Re: Proposed Extensions and Internal Alterations.
At: 2 High Street, Thurnscoe, Rotherham. S63 0SU.
For : Mr. & Mrs. K. Short.
Approval No: 2008 / 0328. Approval Date: 17th. April 2008.

Further to a recent request by our mutual clients who requires to make slight alterations as stated below and following our telephone conversation with your department concerning these alterations as stated below;

AS APPROVED

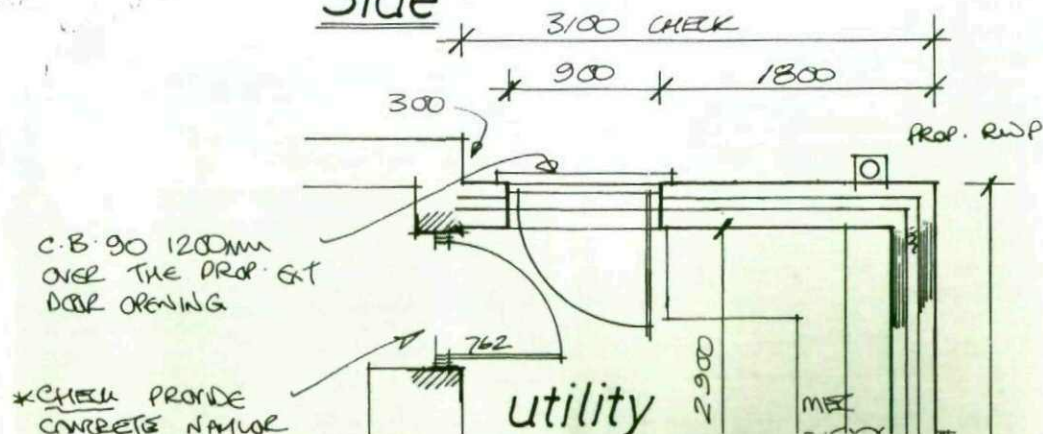
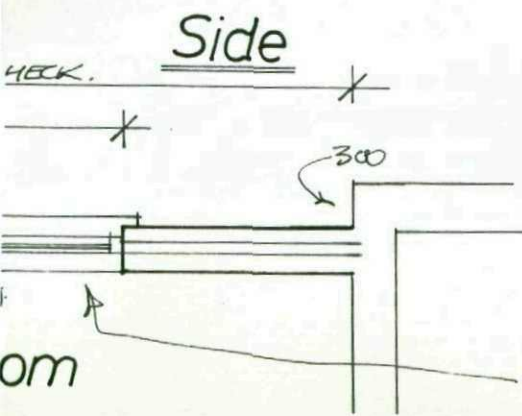
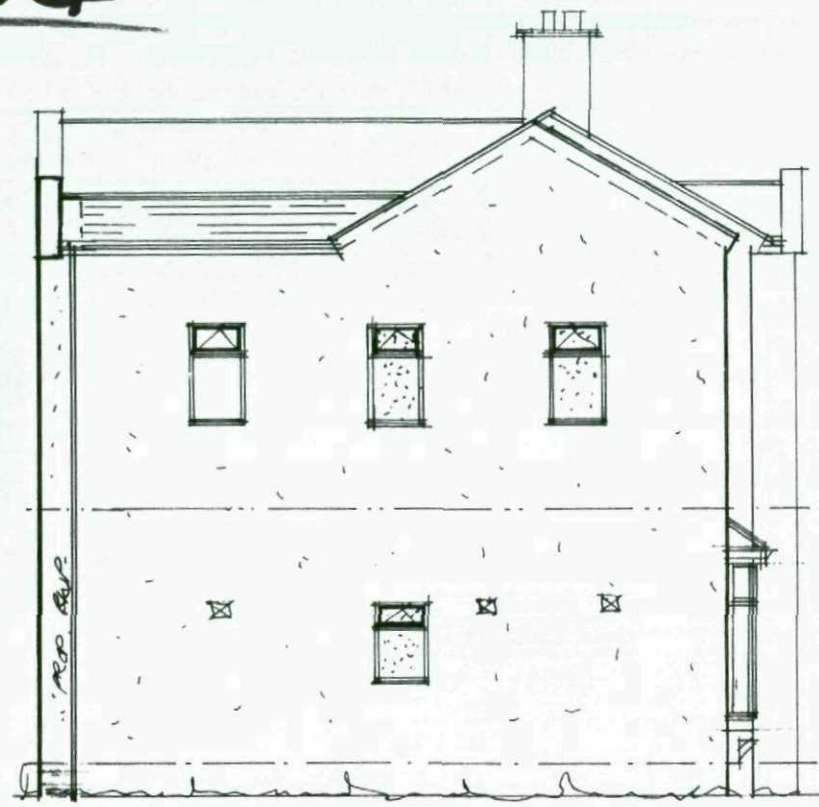
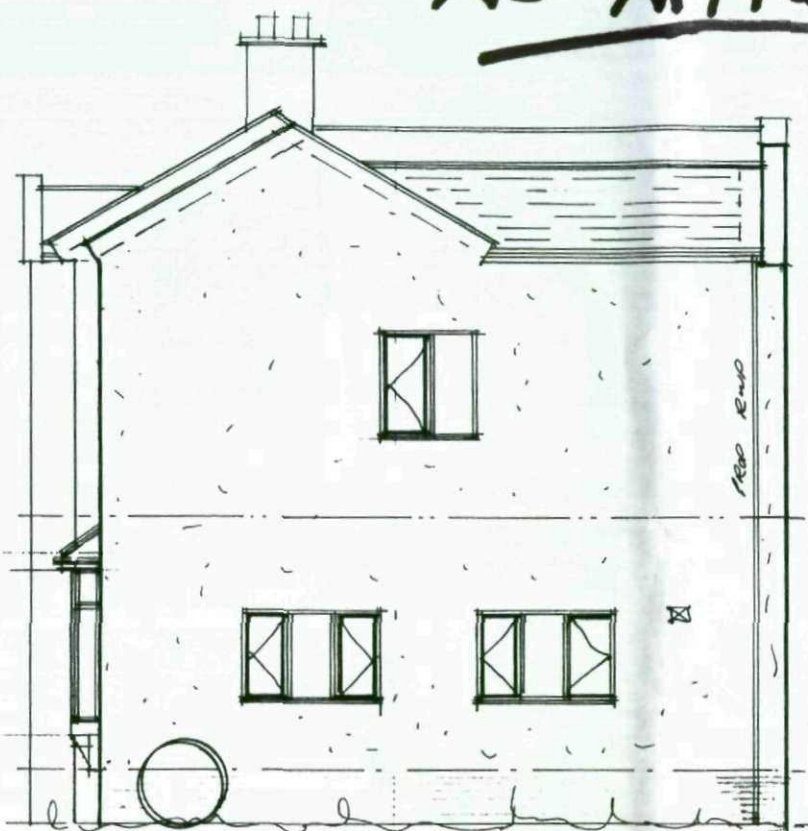
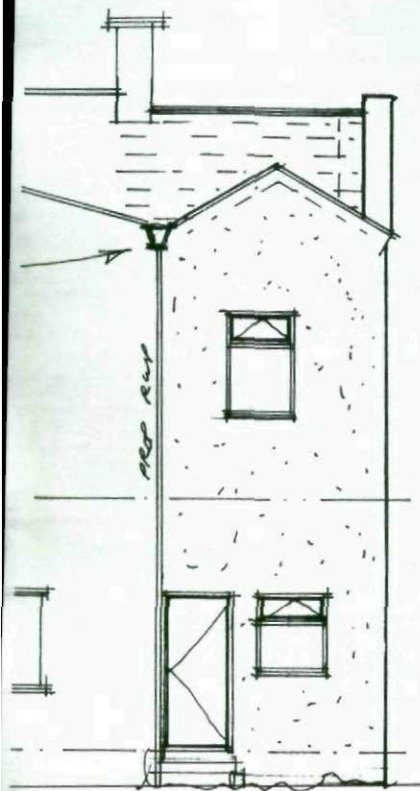
- i) Remove the plant on bay window to the proposed ground floor games room and replace with French doors with side and top panels as shown.
- ii) Internal alterations to the proposed ground floor drying / porch area resulting in re-location to the external door and side window as shown.
